M42 Junction 6 Development Consent Order

8.95 Applicant's Comments on any Additional Information or Submissions Received by Deadline 7

M42 Junction 6
Development Consent Order 202[]

Regulation Number	Rule 8(1)(k)
Planning Inspectorate Scheme Reference	TR010027
Document Reference	8.95
Author	M42 Junction 6 Project Team & Highways England

**OPTION 1: INDICATIVE ALT. ARRANGEMENT TO REDUCE IMPACT ON CHURCH FARM LAND**

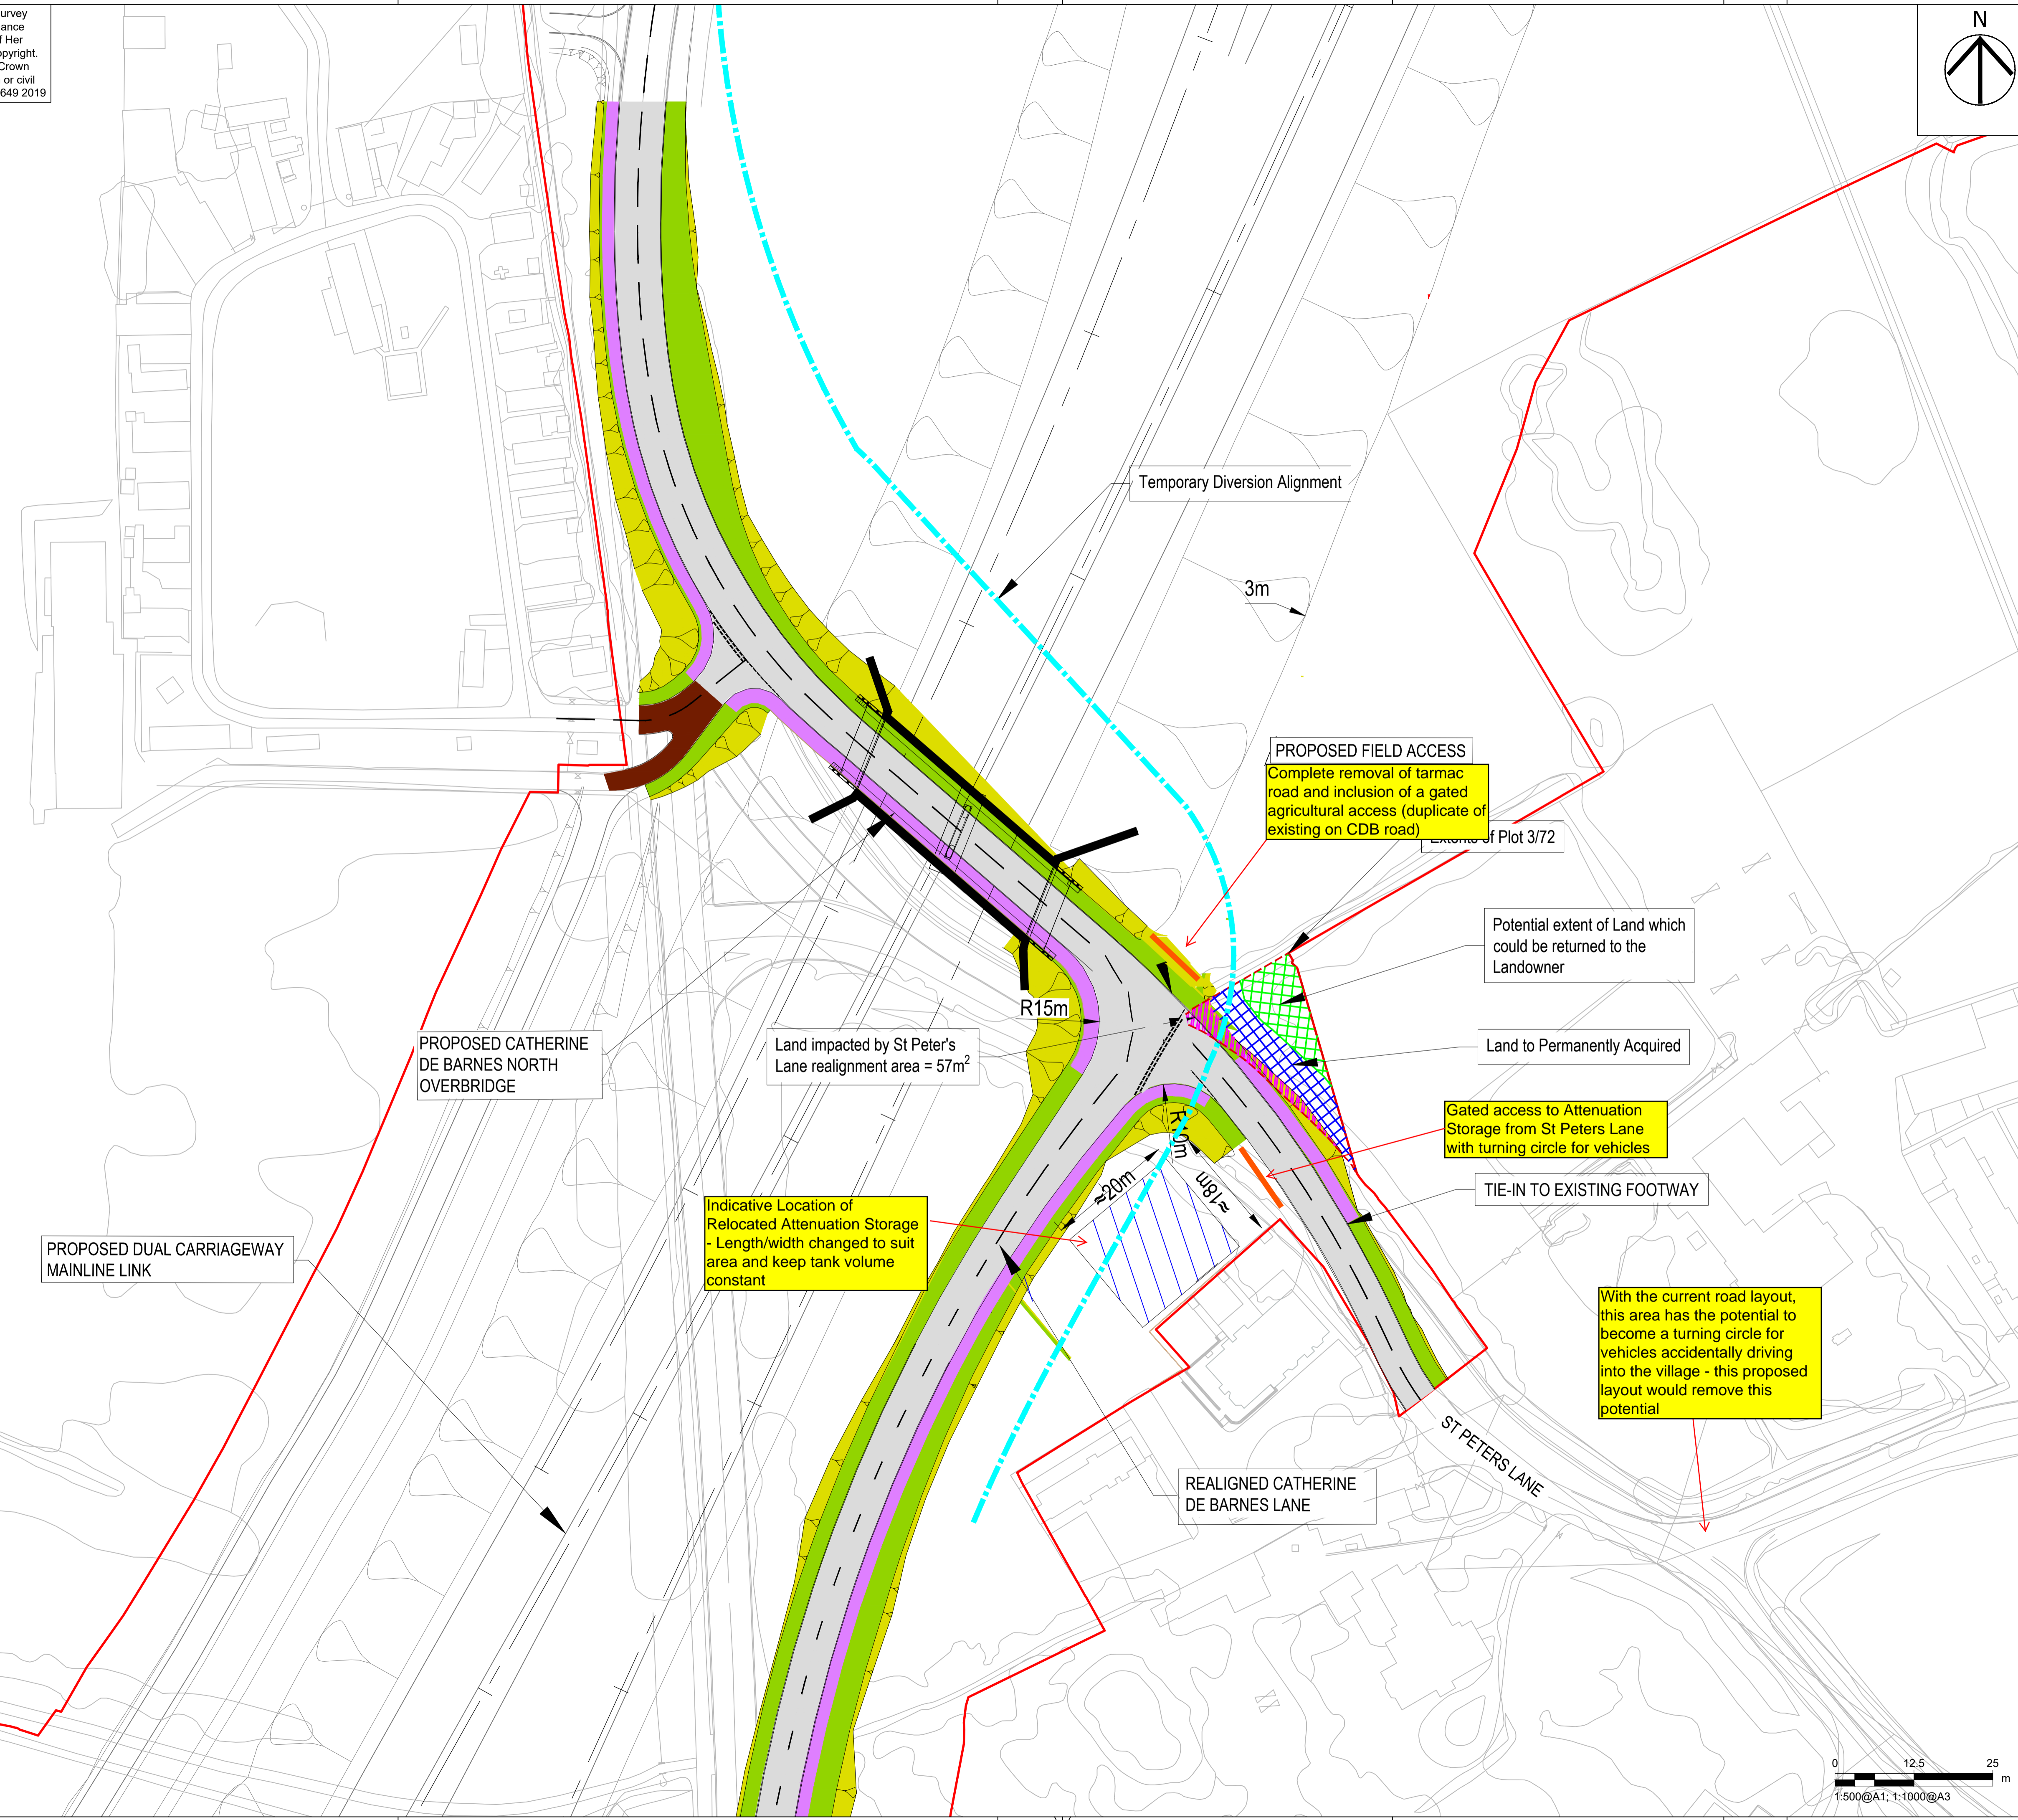
Submitted by	Title	Comments	
			<p>As I said, it is not reasonable unless on agreed terms, and without the use of compulsory powers, to deprive one person trying to earn a living at the expense of another who is purely there for recreational purposes. <u>Highways England have not demonstrated reasonable endeavours to find alternative sites elsewhere and the Inspector required them to so demonstrate or engage with Mr Cattell to acquire, at market value, all of his plots.</u></p> <p>The Applicant's Response:</p> <p>The Applicant considers that the reconfiguration proposals for the WGAA contained within Volume 8.21 [REP2-019], represent the minimum land take required to adequately mitigate the effects of the Scheme on the WGAA facility. This land is therefore "required to facilitate" the DCO Scheme within the meaning of Section 122(2)(b) of the Planning Act 2008. The Applicant considers that there is a compelling case in the public interest for this land to be acquired given the strong protection that the National Policy Statement for National Networks provides to sports and recreational buildings and land.</p> <p>The Applicant has attached the Document entitled 'Warwickshire Gaelic Athletic Associate [sic] Relocation Site Assessment Technical Note May 2018' (the Technical Note) as Appendix 1 to Volume 8.93. This document was originally produced in May 2018 as an internal Technical Note (which is why it retains the draft watermark) but contains options that were shared with the WGAA in Autumn 2018 for discussion. This document is unaltered since this time but contains redacted information where this is deemed sensitive for publication. This technical note shows the alternative locations and reconfiguration options that were considered.</p>
